**Addendum No. 2**

RE: Contract # C203567

**Durham County (U-3308)**

NC-55 (Alston Avenue) From NC-147 (Buck Dean Freeway) To North  
Of US-70 Business/ NC-98 (Holloway Street)

REVISIONS						SHEET NO.
NO.	BY:	DATE:	NO.	BY:	DATE:	S4-4
1			3			TOTAL SHEETS
2			4			68

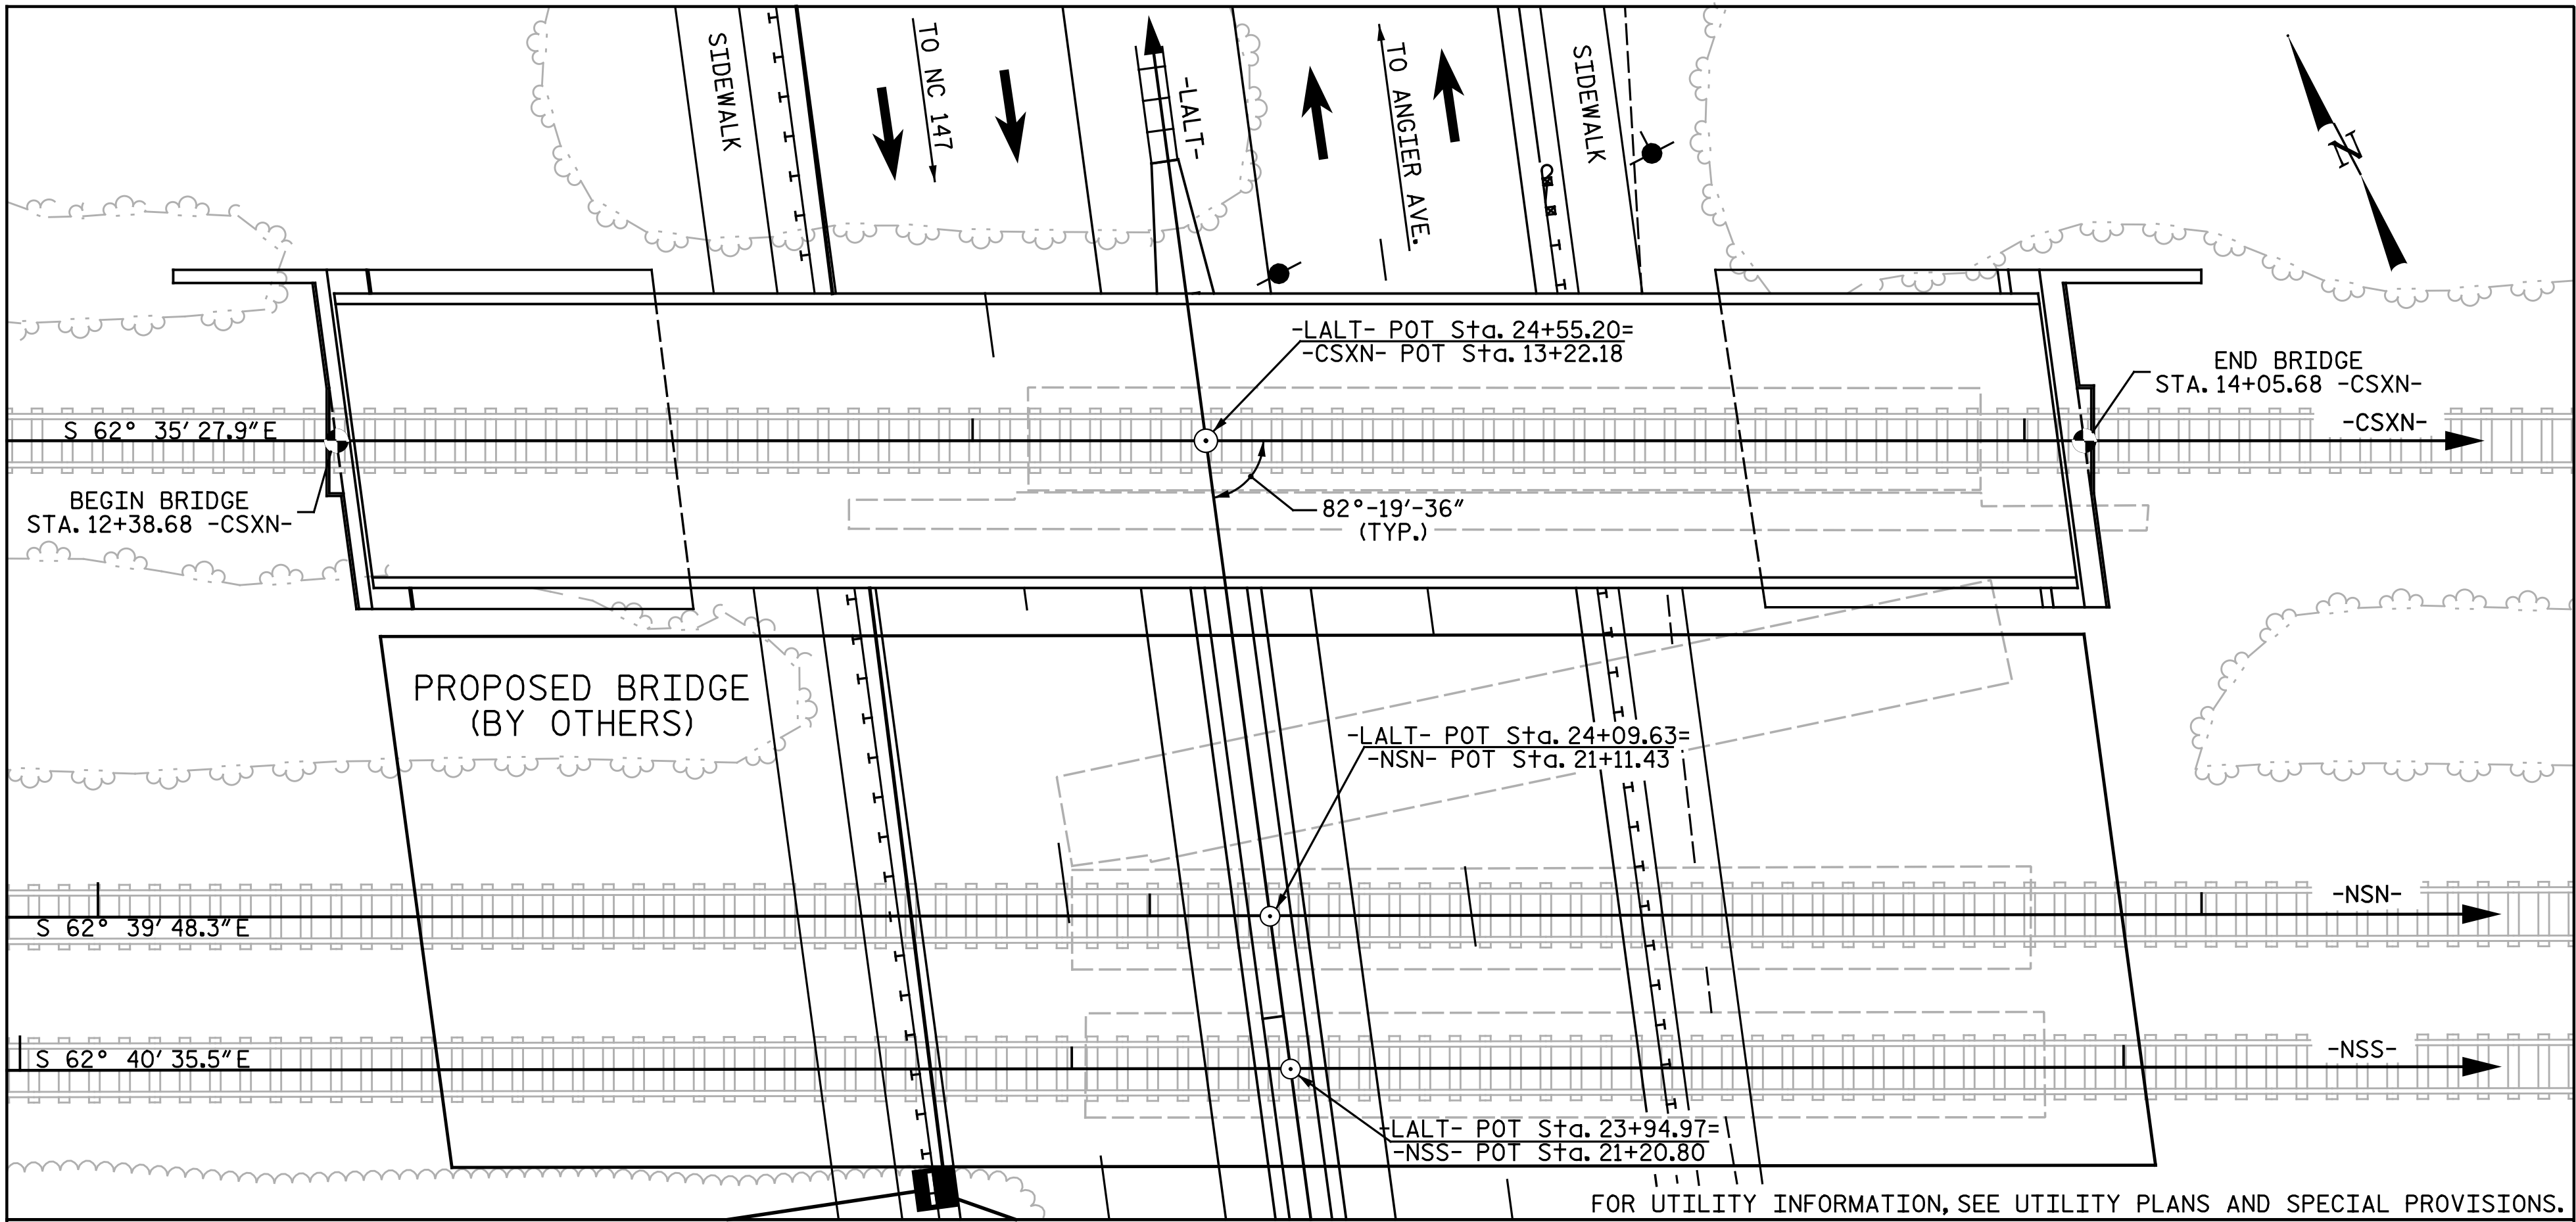
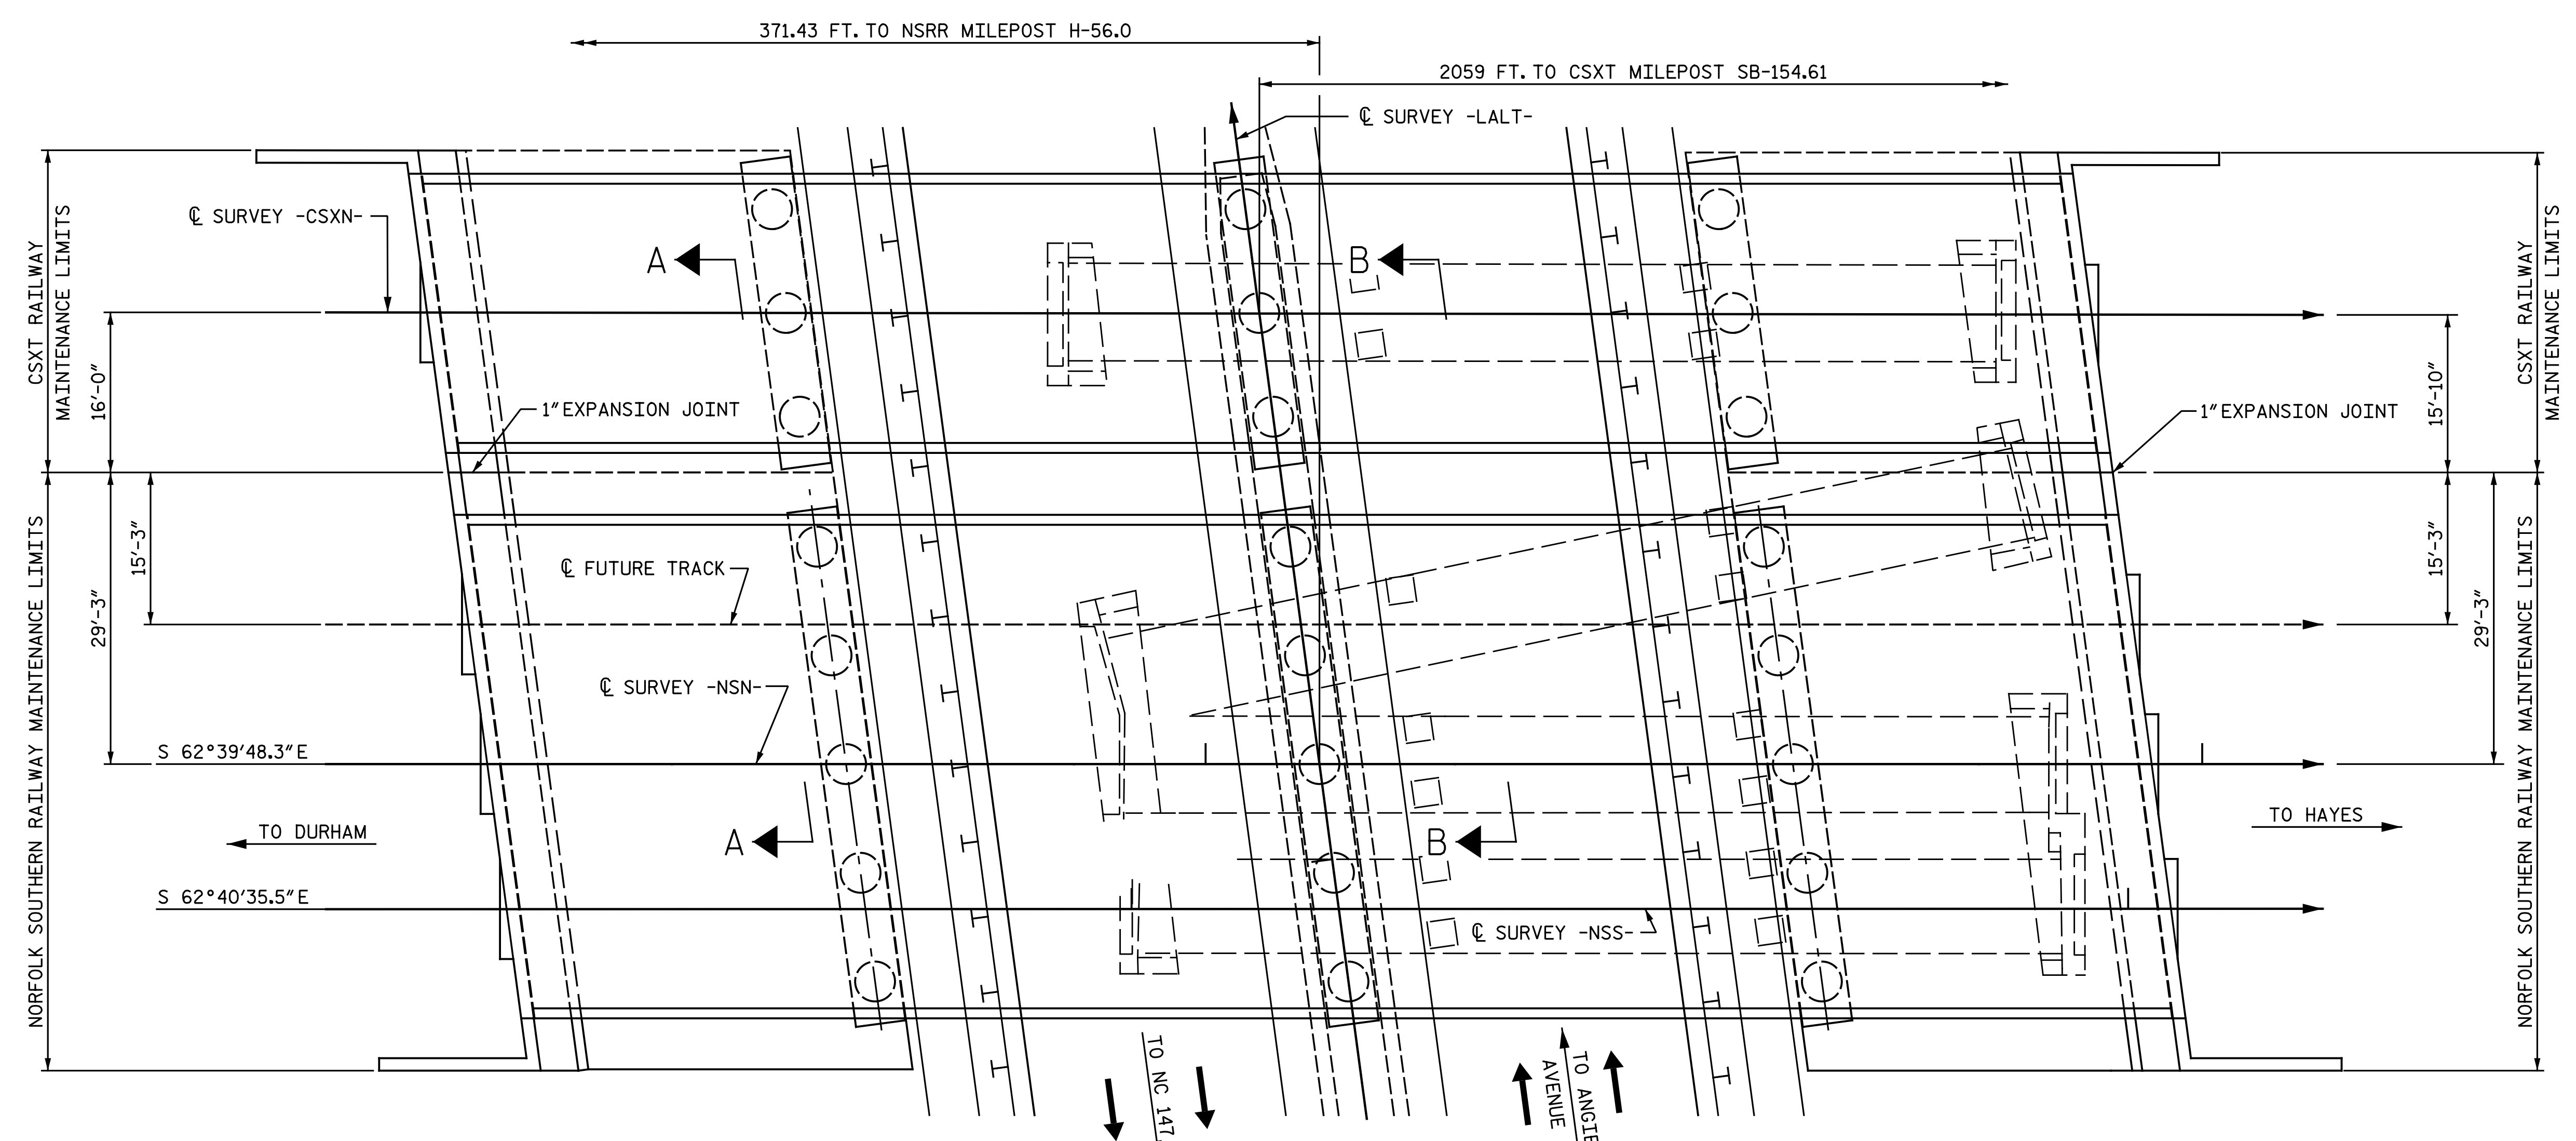
Sheet No.	Revisions
Title Sheet	Revised to change the Letting Date to July 19, 2016
S4-4	Added note referencing "Turn of Nut Tightening" special provision
S4-55	Revised note #20 to not require painting of structural steel, Added note referencing "Turn of Nut Tightening" special provision
S4-63	Deleted note referring to painting structural steel, Added note referencing "Turn of Nut Tightening" special provision
